**Consultation Response from KC,
Trees**

2023/92449 Strines Lodge, Penistone Road, High Flatts, Huddersfield, HD8 8XU

**Erection of single storey rear extension with internal and external alterations (within a
Conservation Area)**

Date Responded: 18/09/2023

Proposed Site Plan 1:200

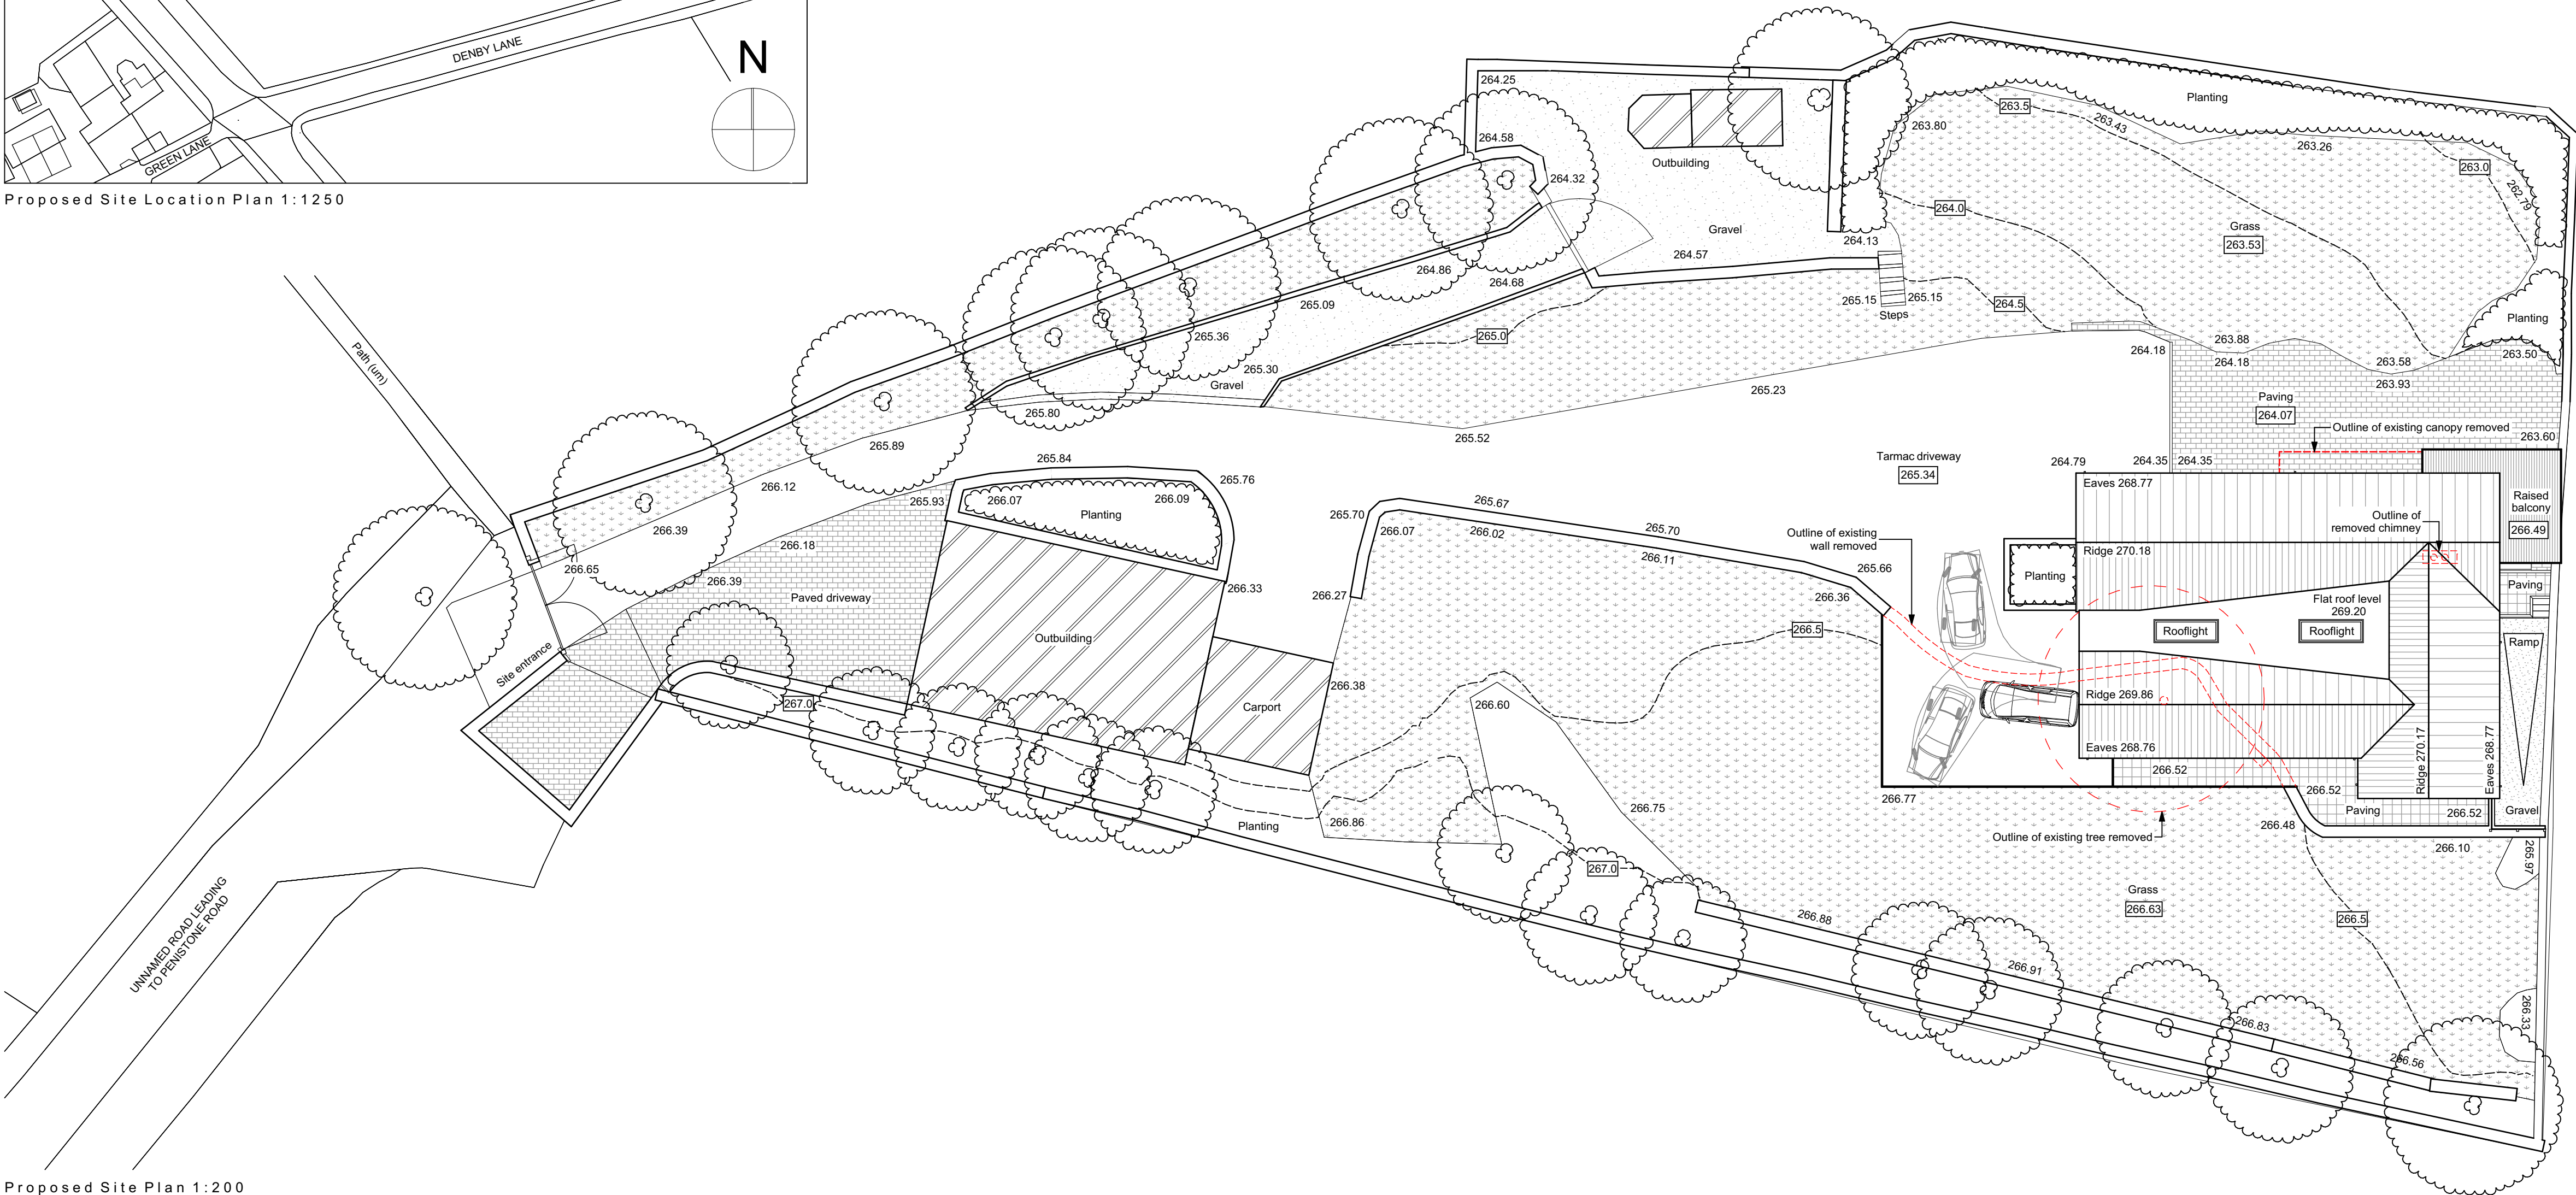
The site is heavily constrained by existing trees that are protected. Trees at site are protected by Tree Preservation Order (09a/95/w4) and are within the High Flatts Conservation Area.

However, now there appears to be no tree information provided about the site and as a result trees can't make worthwhile comments on the application at the moment.

As a result, there is a holding objection to the proposal from an arboricultural perspective as it is conflicting with Policy LP33. This is because the proposal hasn't demonstrated that it has followed the guidance in British Standard BS 5837 Trees in relation to design, demolition and construction that outlines how to successfully take account of and retain suitable trees in proximity to development.
